July 10, 2025

David Gutierrez, PE
Albuquerque Bernalillo County Water Utility Authority
600 2nd St. NW, Suite 201
Albuquerque, NM 87102

**RE: APPLICATION FOR: SP-2025-00047 – SITE PLAN DFT
RESPONSE TO WATER AUTHORITY COMMENTS**

CU-101

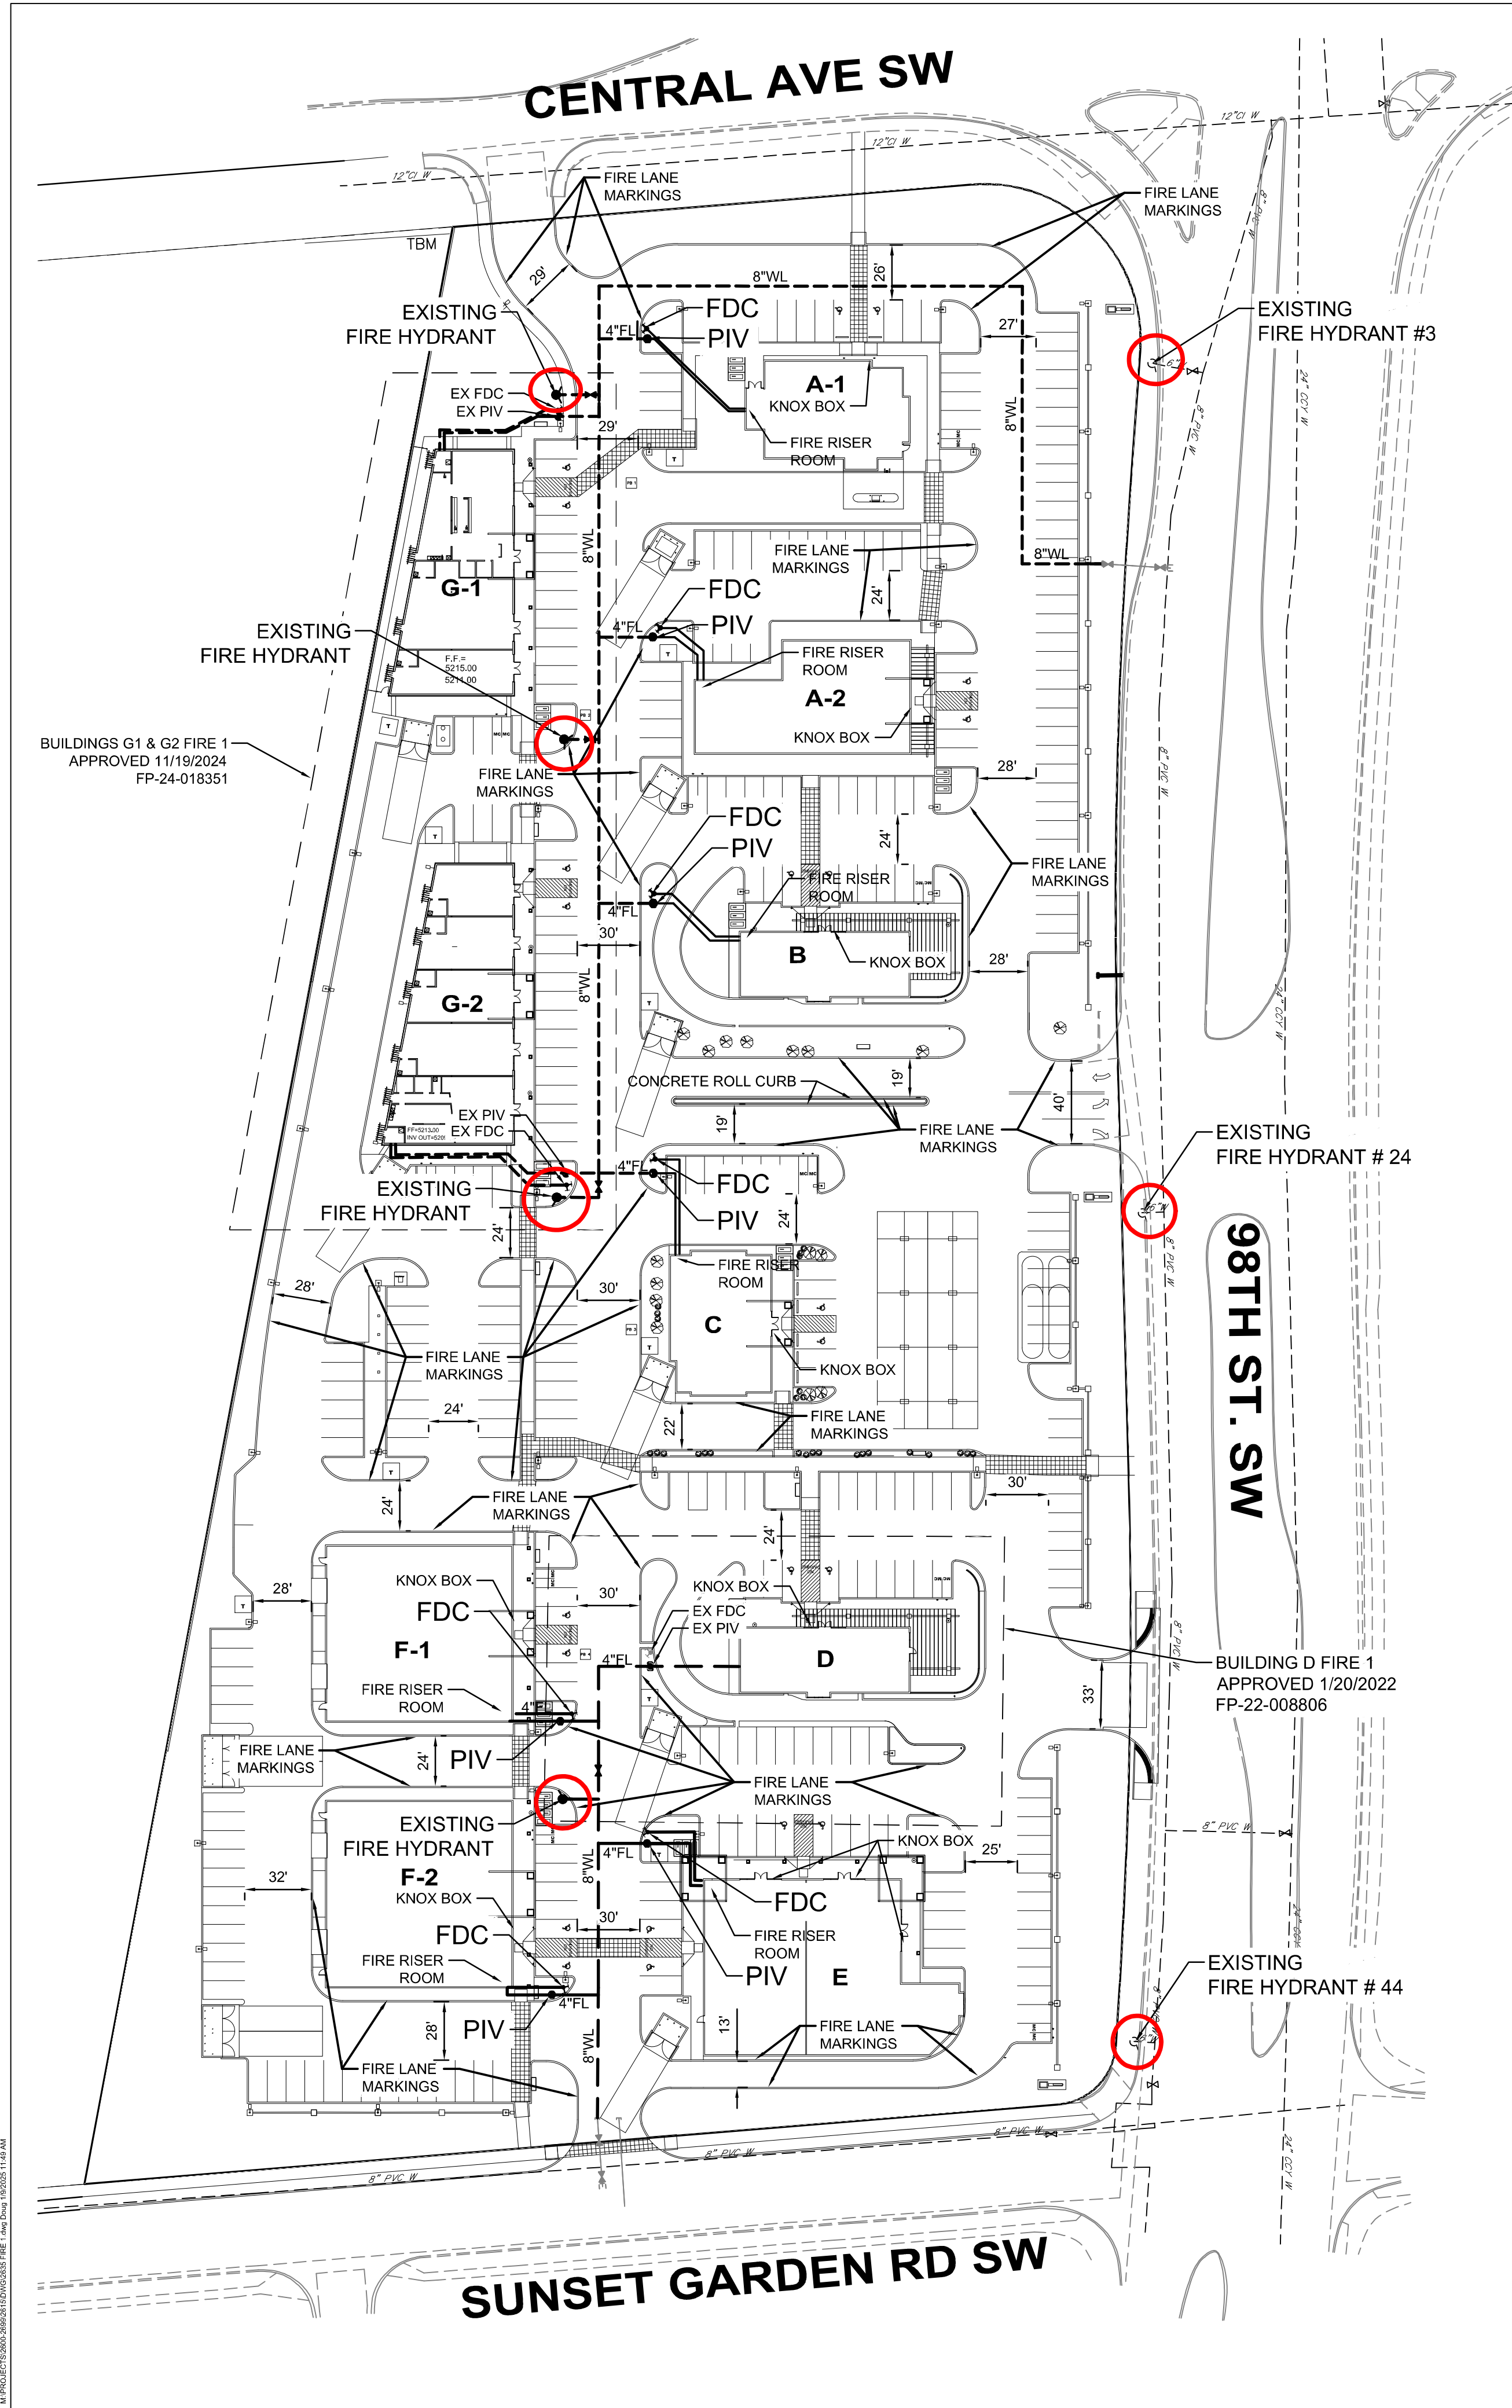
2. *Please provide a utility plan.*

a. *Provide a utility plan that indicates the location of proposed services.*

b. *Show existing public water and public sewer mains and any associated easements on the utility plan.*

c. *Dimension the public water and public sewer easements on the utility plan.*

d. *Please add the following notes to the Master Utility Plan*

i. *Coordination with Water Authority Cross Connection Section will be required to ensure proper backflow containment is in place prior to release of meter for the site. Contact the Cross Connection Section at 505-289-3454.*

ii. *Coordination with the Water Authority Pre-Treatment Engineer is required to ensure the site complies with Water Authority Sewer Use Ordinance. Contact the Pre-Treatment Engineer at 505-289-3439.*

Provided.

All existing public water and sewer mains are shown and labeled on the utility plan. The al exist in the surrounding public rights-of-way.

There are no proposed public water and sewer easements on the utility plan.

The above notes have been added to the Utility Plan.
